From: Sally Munk [Sally.Munk@planning.nsw.gov.au]
Sent: Friday, 18 April 2008 4:20 PM
To: Pradesh Ramiah
Subject: Fraser Drive - Preferred Project Report - MP06_0243

Preferred Project Application - MP06-0243 (DA07/0589) for 152 freehold residential subdivision (providing for attached and detached dwellings) and future development lot at Lot 9 DP 1039569, Fraser Drive Tweed Heads South

Attachment – Council Officers Comments

FIGURE No.DA 20
POST DEVELOPMENT
STORMWATER NETWORK

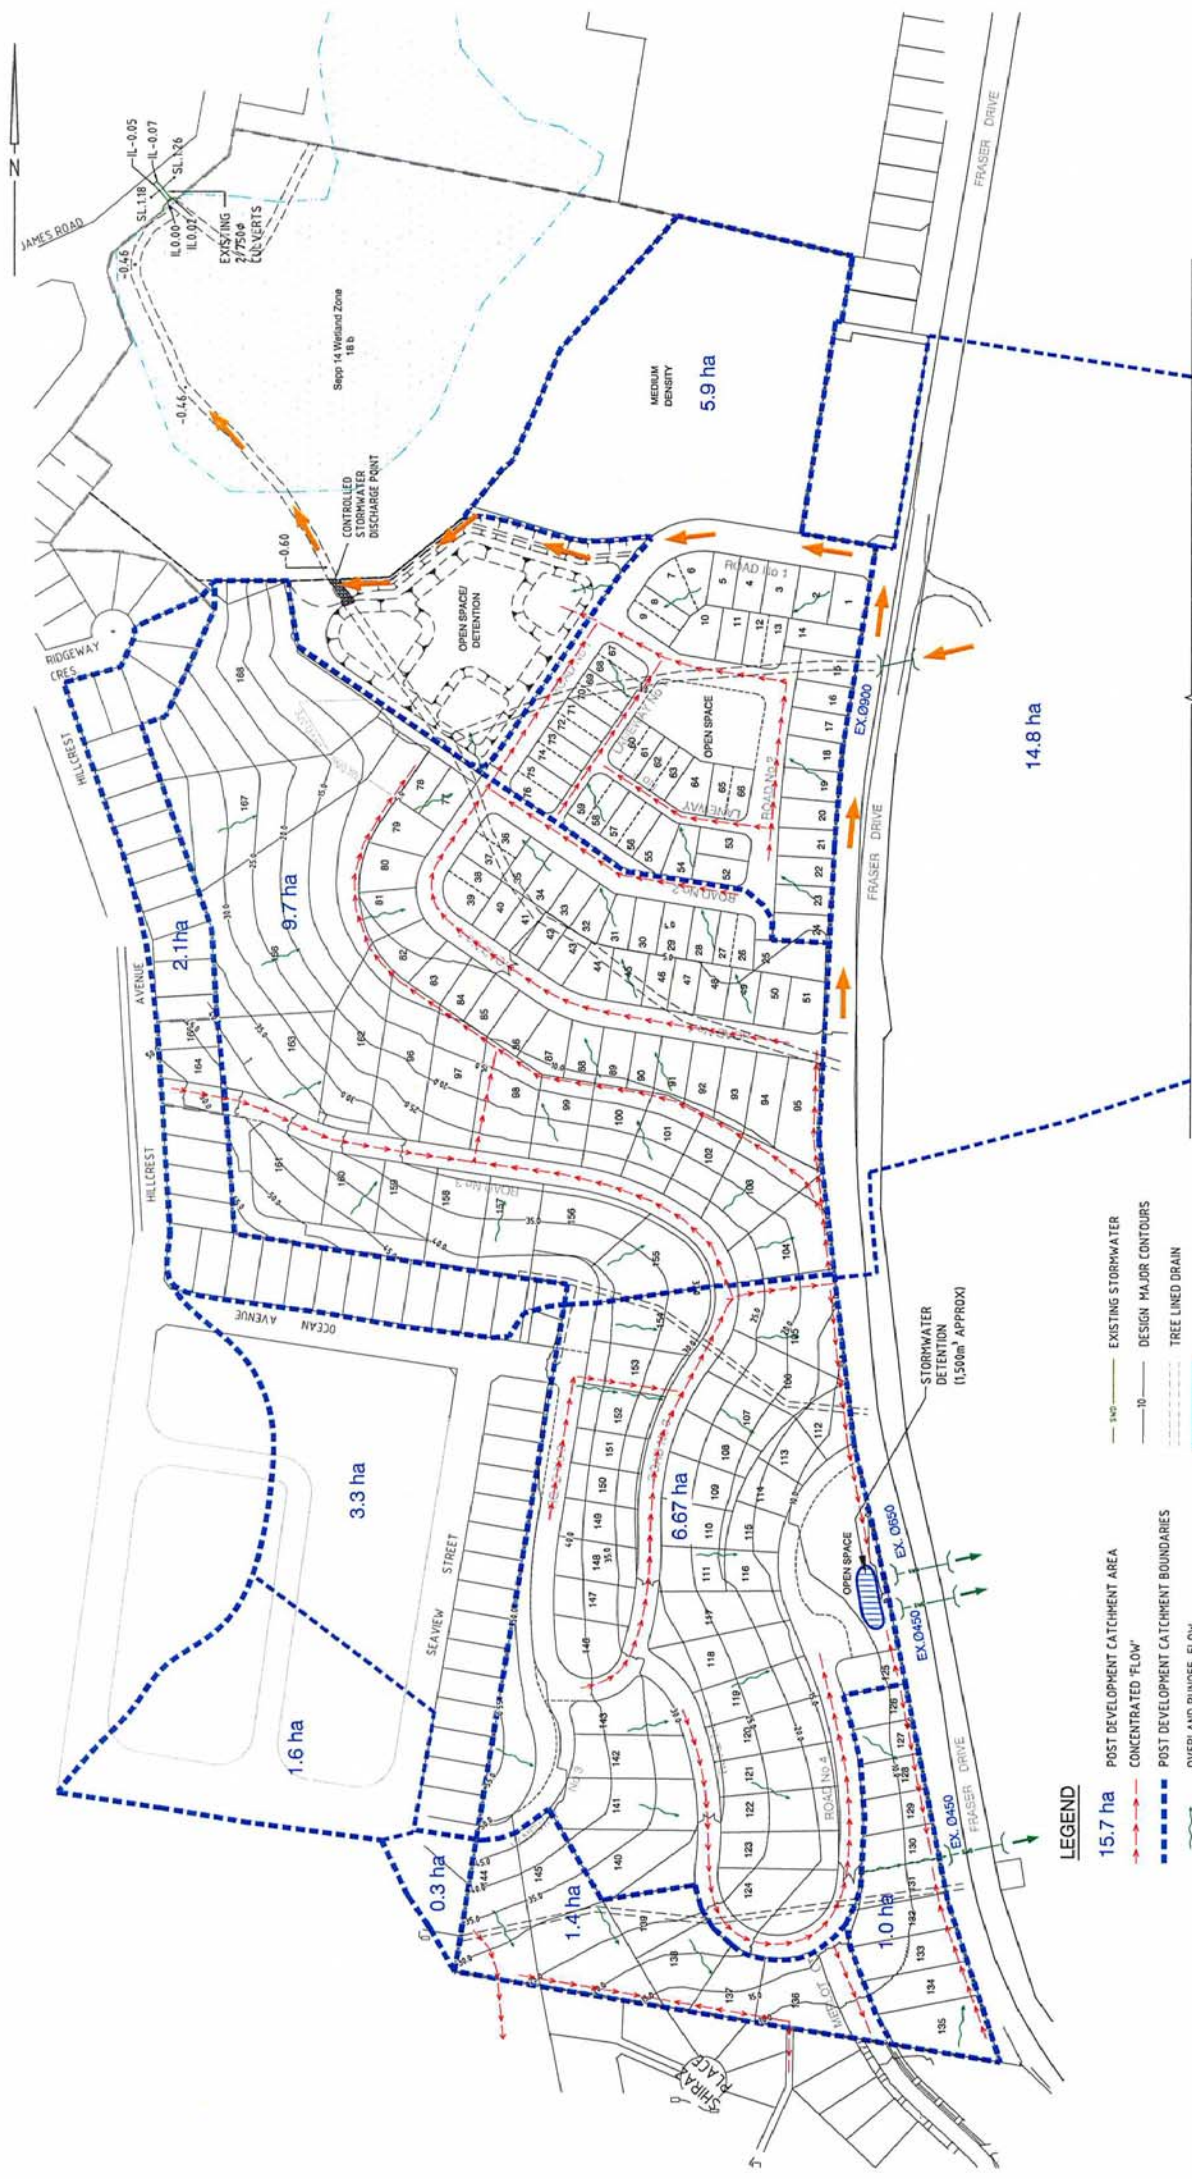
site would exceed 10% slope in the absence of the wall.	
STORMWATER ISSUES		
27. Provide design confirmation that the 3 cell 1500mm diameter piped system is adequate to cater for ARI 100 year stormwater runoff from a future urbanised catchment east of Fraser Drive, without resulting in flooding in Fraser Drive. Preliminary design details of Q100 inlet structures shall also be provided.	This piped system has been modelled in PC Drain. Any head loss that may occur through the bends has been accounted for in this modelling. Our developer can not impose construction requirements onto another landowner. If Council want the culverts to cross Fraser Drive, then the existing landowners future access and current drive way entrance would have to be moved and the existing drainage path 900 dia culvert would have to be re-routed. It is not reasonable to impose conditions which we can not lawfully impose on another landowner. It is also unreasonable to impose the requirement for the allowance of flows from a developed upstream catchment. Given the requirement for our site to have on site detention to maintain existing peak flows, it should be the responsibility of the upstream property owners to also maintain existing peak flows from their site. Should this condition remain it would be necessary for the applicant to request stormwater headworks credits for any additional infrastructure and loss of land due to allowing for flows greater than the property currently accepts.	The open channel within a Council easement that traverses the development site currently provides the capability to discharge all flows (under current and future conditions) from the eastern catchment through the site to the SEPP 14 wetland. As the applicant is requesting that Council relinquish this service, equivalent drainage must be provided, and must be capable of catering for the potential increase in runoff from a fully urbanised eastern catchment (as the zoning currently permits). FURTHER INFORMATION REQUIRED.

28. Amend the design of the 3 cell 1500mm diameter piped system to provide a straighter alignment (eliminating 90 degree bends) between the catchment east of Fraser Drive and the bypass channel for the treatment/detention ponds in Part A of the subdivision, to maximise inlet capacity and minimise the chance of blockage. Further investigation of solutions to the potential conflict between stormwater services and the existing water main in Fraser Drive shall also be provided, to allow for the relocation of the stormwater inlet to the eastern side of Fraser Drive to eliminate the existing 900mm culvert.	This issue has been addressed in Appendix B. In summary, Council have previously requested that this site and the site across the road share a common intersection for access to Fraser Drive. The entrance to this site was placed in accordance with Council's recommendation. As the stormwater pipes are located under the roadway due to their size, it makes it impossible to align the stormwater line perpendicular to Fraser Drive without affecting opposite properties driveway access, or possible future development. Even placing pipes under Fraser Drive at a 45 degree angle to the road would require earthworks in the opposite property to change the existing overland flowpath, and re-grade it to the new culvert crossing.	Limitations on works on adjoining land are acknowledged. The proposed arrangement of the 3 cell 1500mm diameter pipes is satisfactory to Council, provided the applicant can demonstrate that there is an alternative failsafe surcharge flow path from Fraser Drive to the SEPP14 wetland. This is currently available in the form of an open channel within an easement benefitting Council, and this will not be relinquished unless a satisfactory alternative system is in place. This flow path is necessary to prevent flooding impacts in Fraser Drive and adjoining low lying properties. FURTHER INFORMATION REQUIRED.

entry statement plan

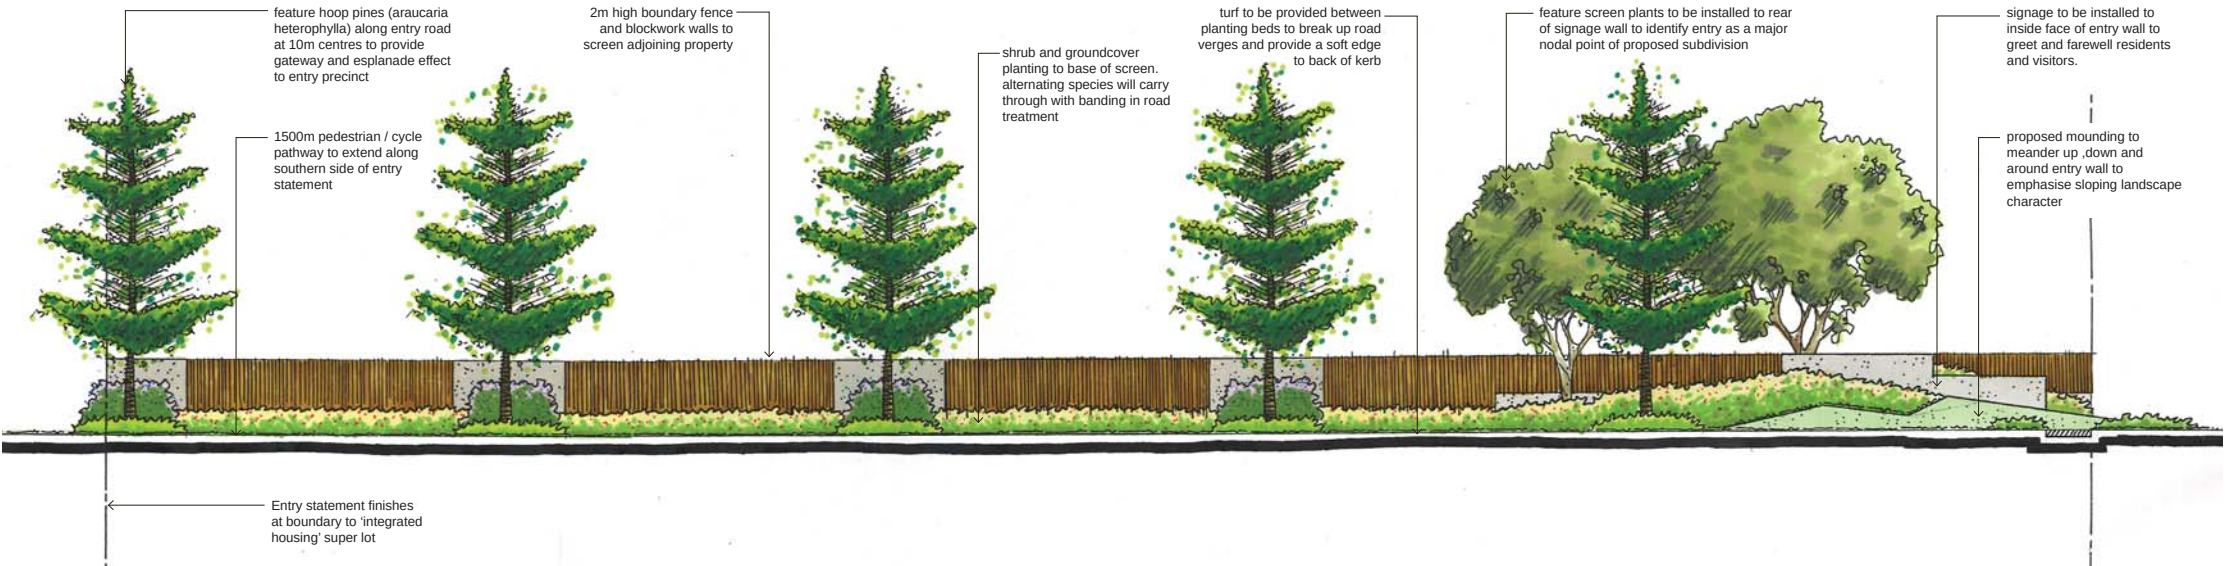
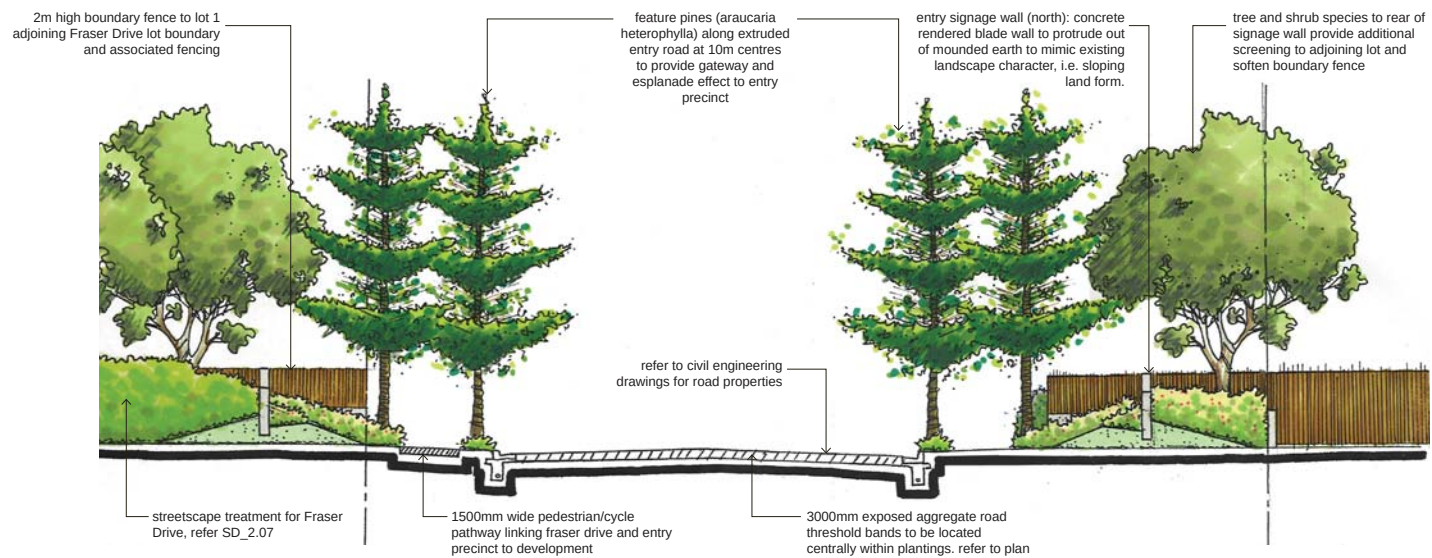
The landscape plans indicate Norfolk Pines apparently adjacent to private residences. Advice is required about actual distances to private land.
